**Consultation Response from KC,
Highways Development Management**

2024/93017 51, Longcroft, Almondbury, Huddersfield, HD5 8XW

Conversion of garage to habitable accommodation and erection of fence

Revised Drawing Response

Block Plan - 1:500

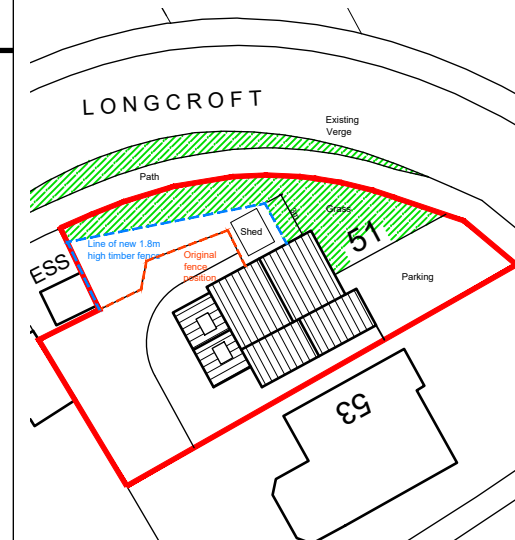
In the revised drawing the fence line has been shown to be offset by approximately 1m along the side connecting to the electricity sub-station. This would now allow for a 25m visibility splay to the right for vehicles exiting the garage/parking space for No 55 Longcroft, however we would request that a condition is added to ensure that anything within the area between the fence and the rear of the adopted footway is maintained to a maximum height of no greater than 1m to ensure clear visibility for drivers.

The 1m offset will also allow an increase of forward visibility around the bend on Longcroft adjacent to the application site.

Greater concern has been raised about the line of the new 1.8m high fence surrounding the property. This has already been erected and so is submitted for retrospective permission, however drawing No 0302-P02 shows that the line of the fence is to be amended and angled inwards from the adopted highway. This angled alignment, although still limiting visibility more than before the fence was built, will allow for forward visibility of approximately 25m around the bend from the nearside kerb as prescribed in Manual for Streets and the Kirklees Highways Design Guide. For a 20mph road the guideline forward visibility length is 24.87m and so this is acceptable.

However, the location of the fence does reduce the visibility splay to the right for vehicles exiting the parking space/garage for No 55 Longcroft to only 17m and this would be below the recommended visibility splay y-length of 25m. In order to achieve this, the fence within the visibility splay for the garage at No 55 would need to be lowered to under 1m or the boundary of the fence moved inwards approximately 1m towards the electricity sub-station, allowing for a 1m grass strip between the fence and the rear of the footway at this location. Any planting within this 1m strip should be kept to below 1m in height by planning condition.

With this we are satisfied that the forward visibilities and the visibility splay for vehicles exiting the garage at No 55 are within standards and therefore would not like to object to the application but

Upon completion of the fence works as shown in approved drawing 0302-P03, sightlines along the frontage of the site between the fence line and the rear of the adopted highway on Longcroft shall be cleared of all obstructions to visibility exceeding 1 m in height and these shall be retained free of any such obstruction throughout the lifetime of the development.
